Engineers Comments Regarding Surface Water Drainage

APPLICATION **BR/311/18/PL**

Site Address: Land to the east of University of Chichester Upper Bognor
Road Bognor Regis PO21 1HR

Description of Works: Erection of 176 bedroom student accommodation building with
associated hard & soft landscaping. This application may affect
the setting of listed buildings, may affect the character &
appearance of the Upper Bognor Road, Mead Lane
Conservation Area & is a Departure from the Development
Plan.

- SITE BOUNDARY
- EXISTING POTABLE WATER PIPE WITH EASEMENT
- EXISTING FOUL WATER PIPE WITH EASEMENT
- EXISTING CULVERTED WATERCOURSE

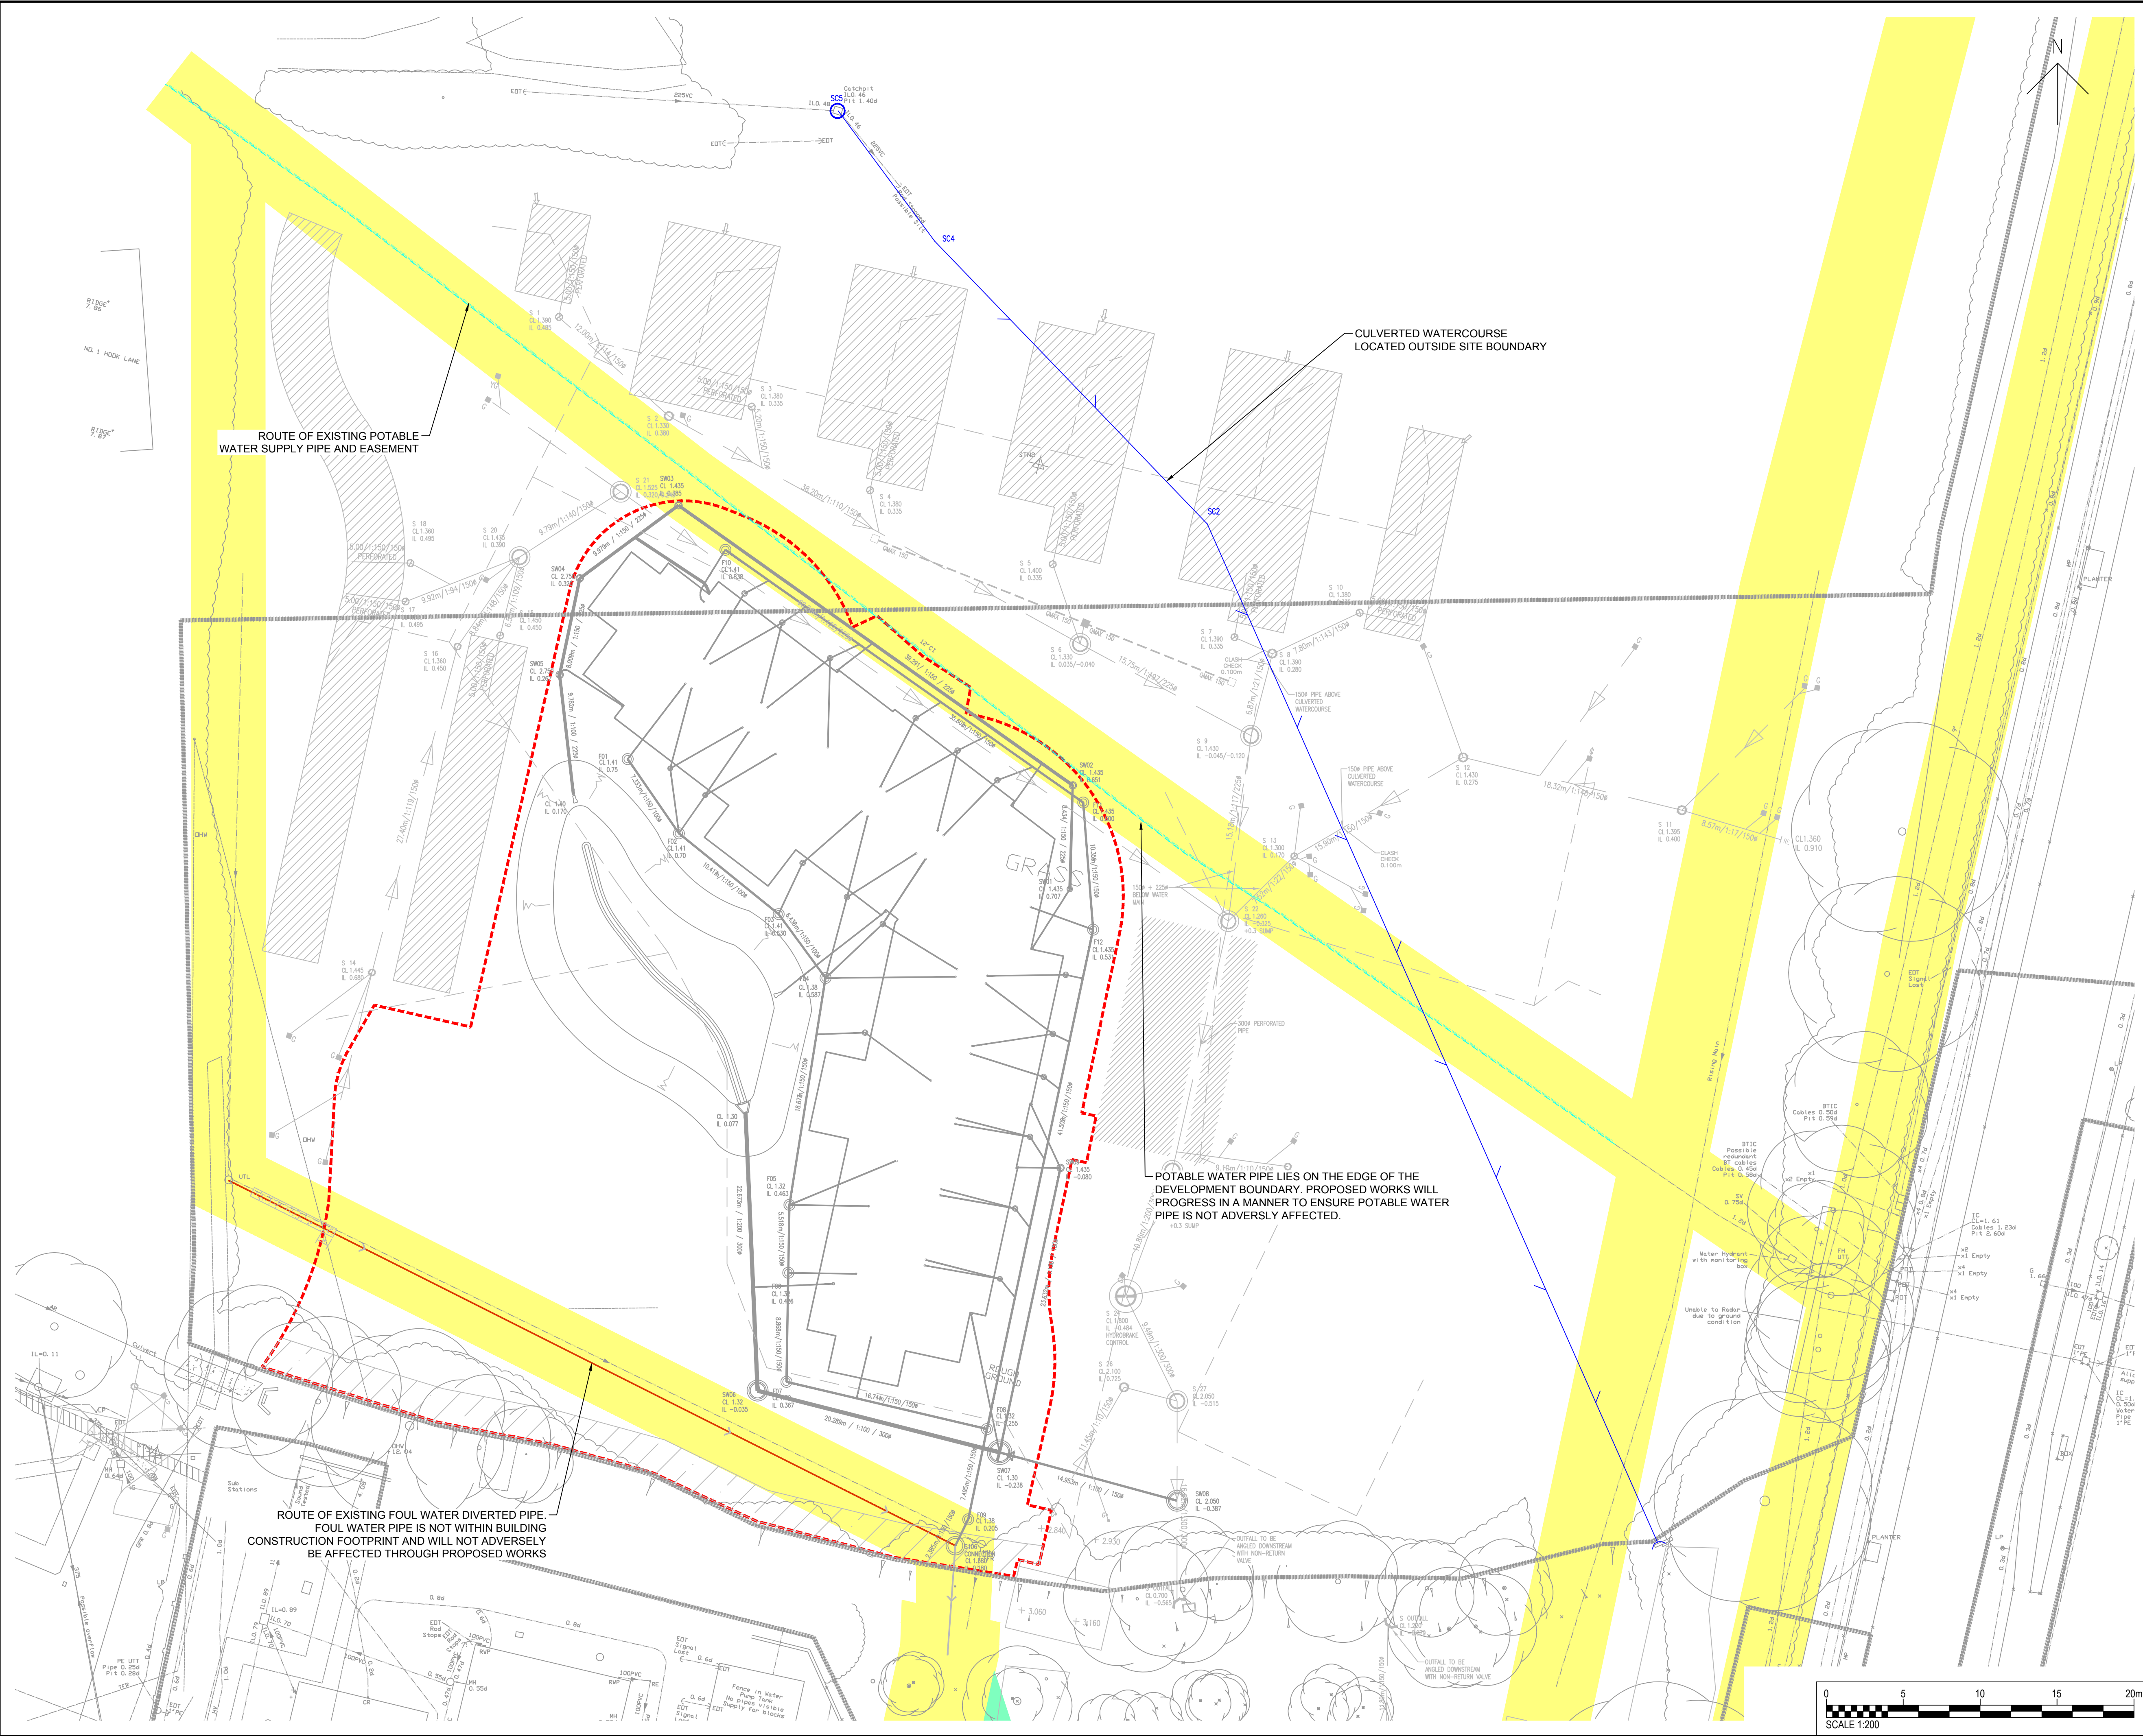
There is a private sewer running through the site which is in a poor state of repair. The applicant has been in consultation with us regarding this previously. The corrective measures identified must be undertaken. The derelict culvert that is also present in this area should be removed, the applicant is advised to contact us regarding this.
